CITY OF ALBUQUERQUE

December 17, 2014

Re: Starbucks, 700 Juan Tabo NE
Preliminary Grading Plan
Engineer's Stamp Date –no stamp- (K22/D006B)

Date: 11.19.14
To: Curtis Cherne, P.E., Hydrology
From: Jay Newell, P.E.
RE: Starbucks – Juan Tabo & Copper; Project #1003777
Hydrology Formal Comment Responses

C301

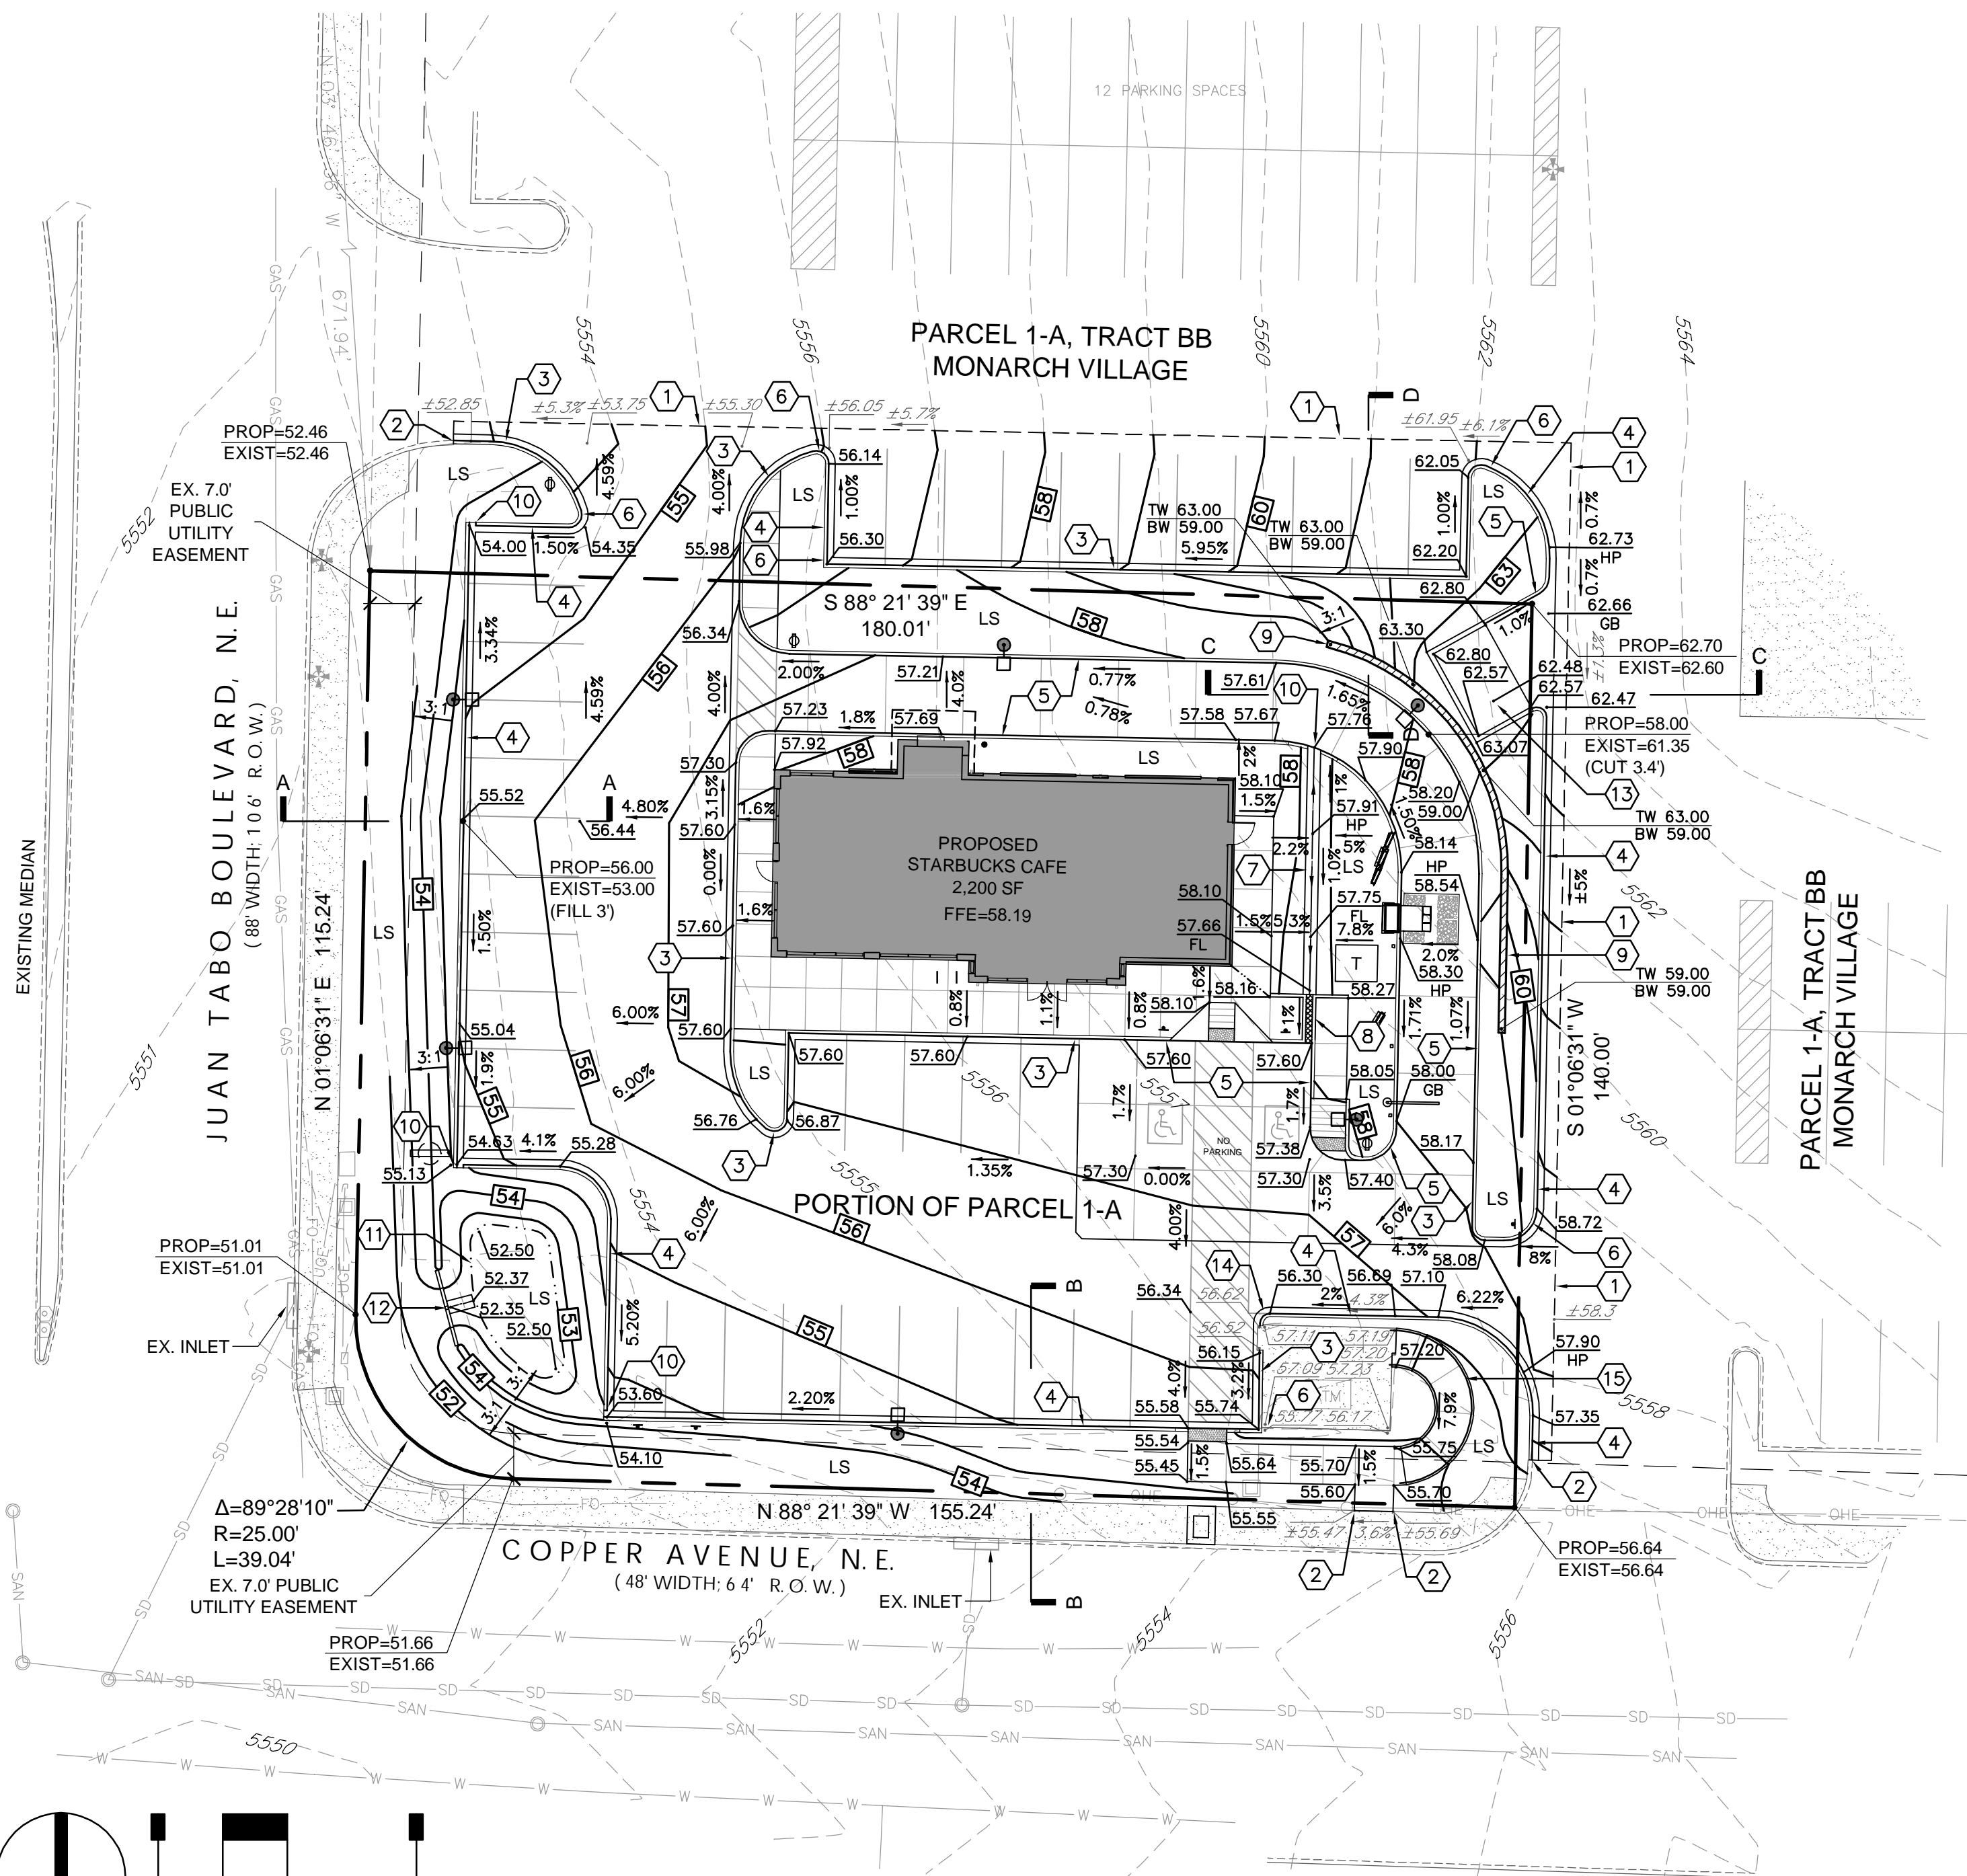
- Specify the width of the curb openings. A detail may be helpful if the sides are tapered.
- The refuse enclosure is to drain through a sand filter then to the sanitary sewer.
- It appears the site does not fit on the proposed lot. If construction is to occur on the adjoining lot, written approval from the adjoining lot property owner is required or the proposed lot could be bigger.
- Please include the word "drainage" in the Sheet Title (e.g. Grading and Drainage Plan).
